Addendum 03

Date: September 28, 2011

To: Wright Ryan Construction (Construction Manager)
From: Ben Walter, CWS Architects
Regarding: **Elm Terrace** – Portland, Maine
Subject: **Addendum 03**

Drawing Number:
S1.1

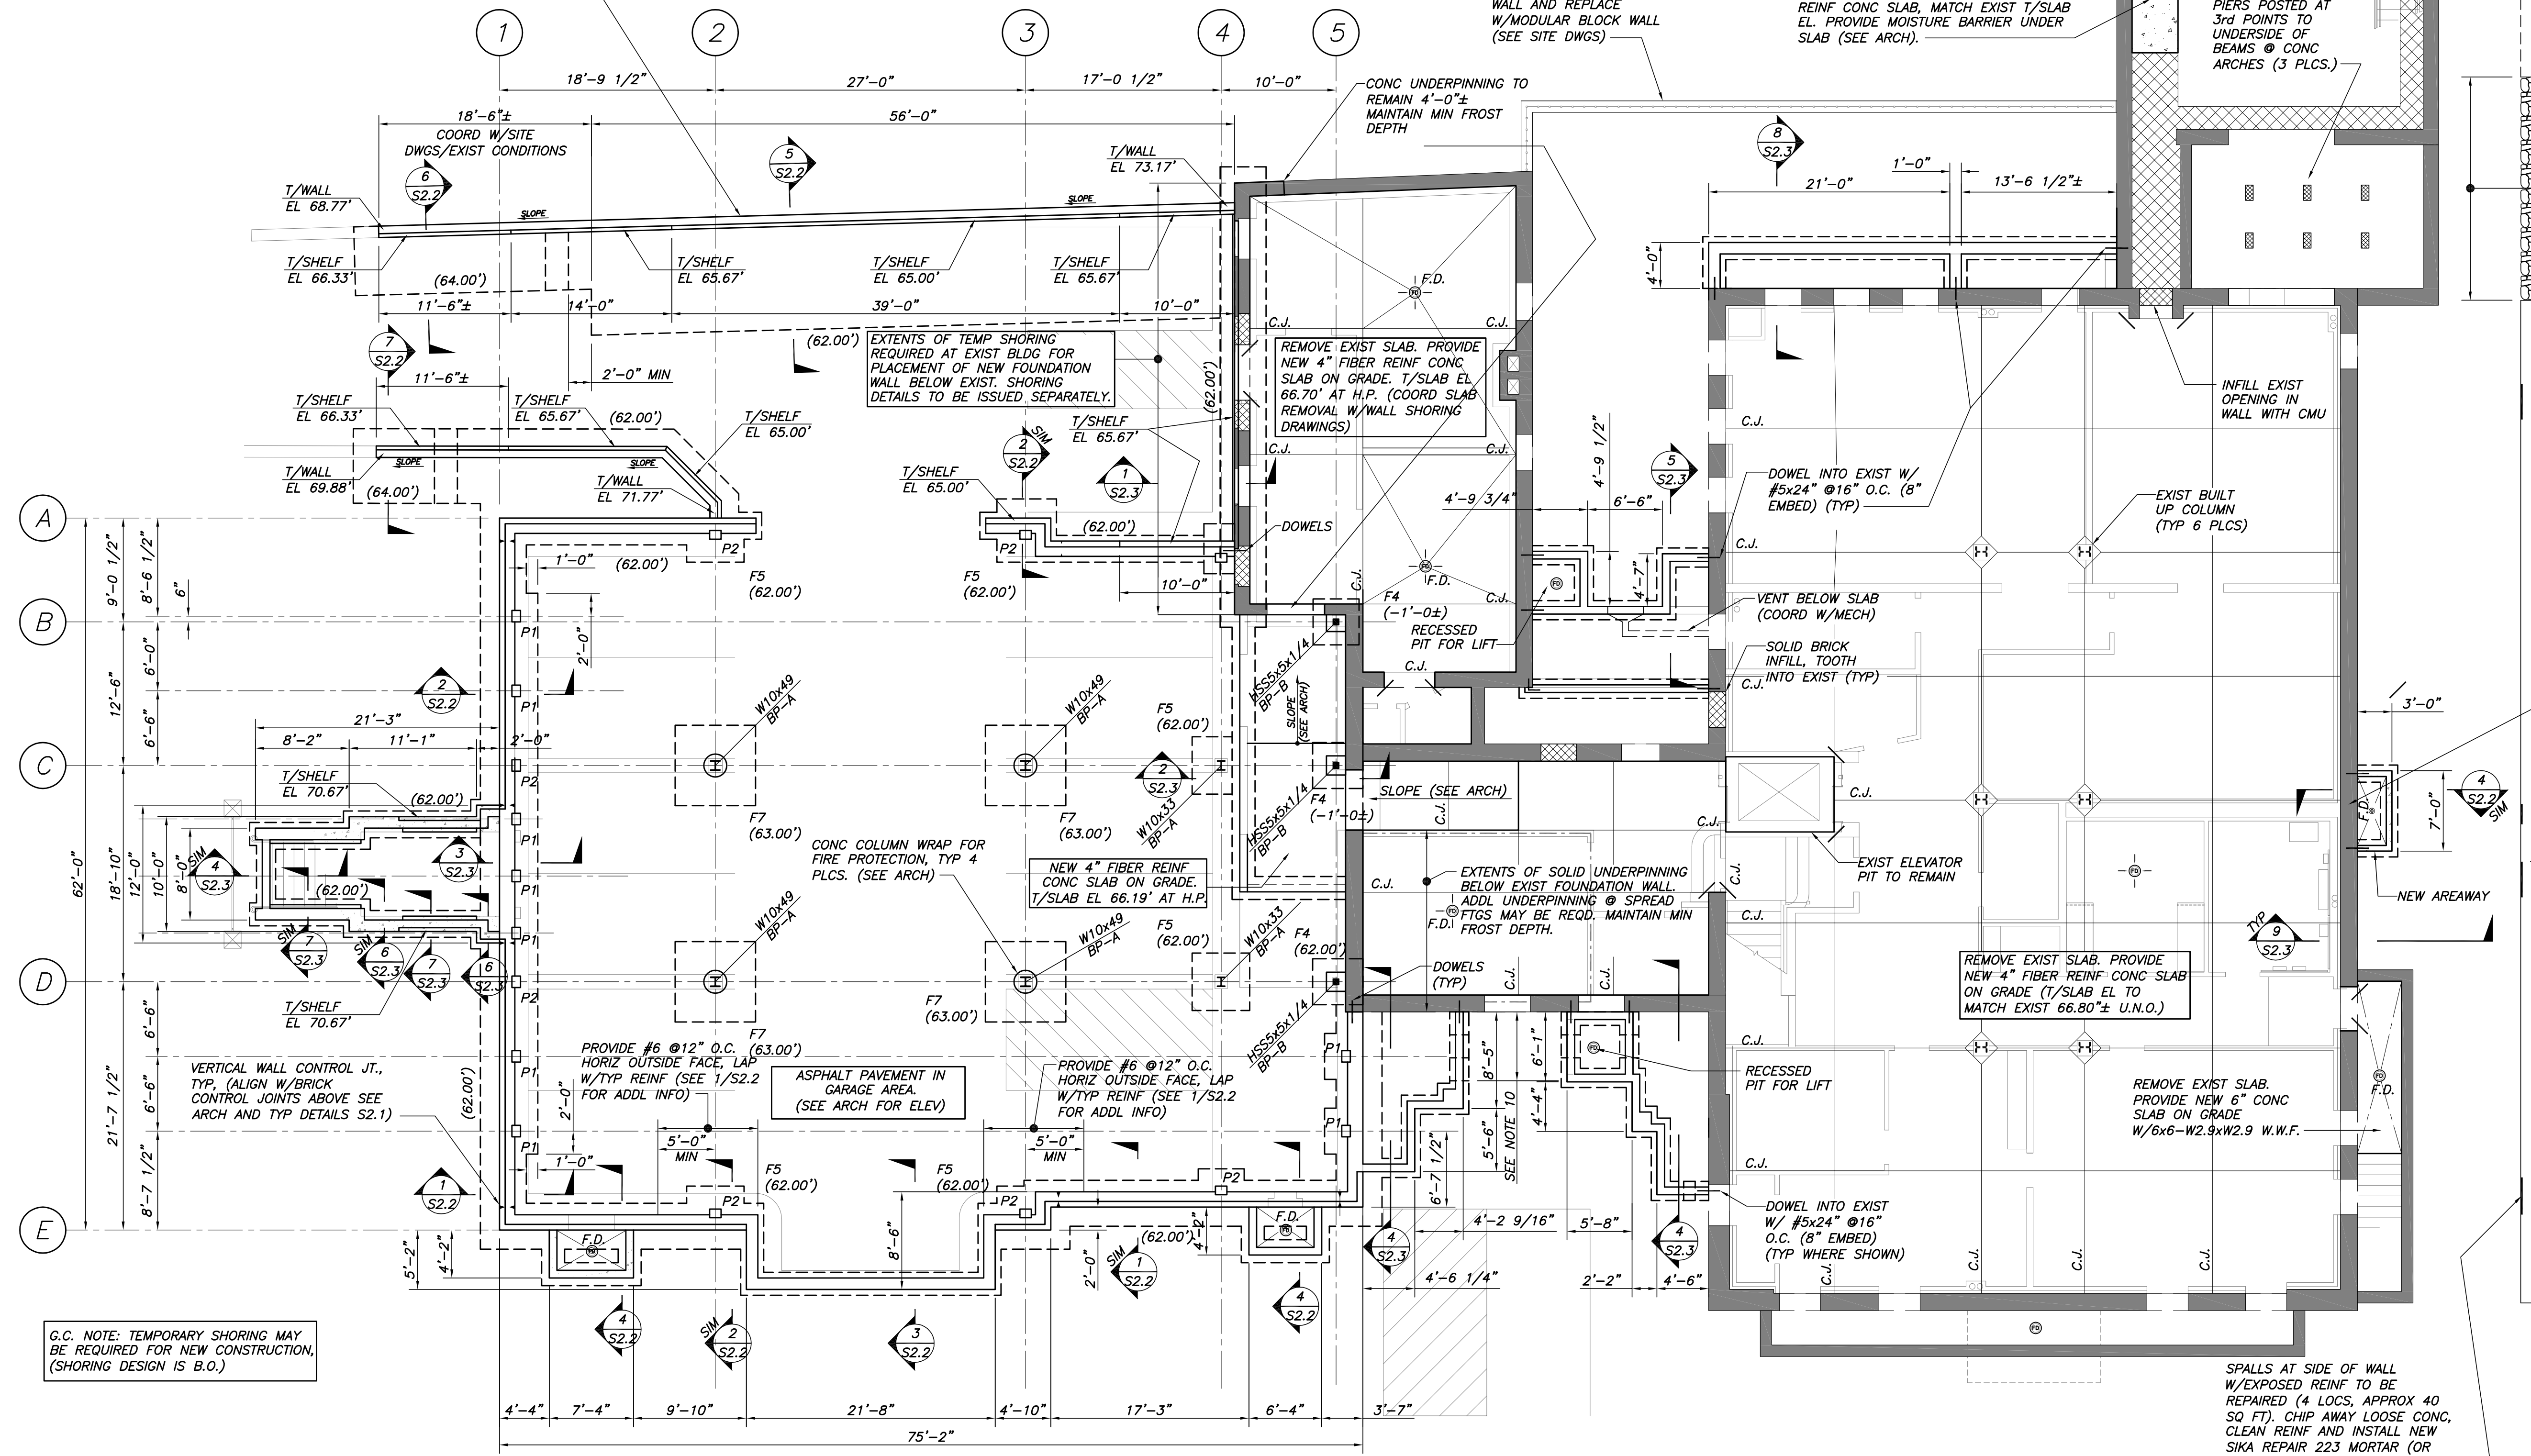
7. Replace detail 2 on Drawing S3.2 with the attached SKS-1-1.
8. Replace detail 3 on Drawing S3.2 with the attached SKS-1-2.
9. Provide square concrete column wraps (not round as indicated on Drawing S1.1) at all six (6) steel columns in the enclosed parking garage area [PARKING GARAGE - 001] per attached SKS-1-3.
10. At all continuous bearing floor trusses to be installed directly over the first floor concrete slab subfloor structure of the building addition wing, a) MSR lumber ratings are not required; and b) the bottom plate of the trusses shall be pressure treated.
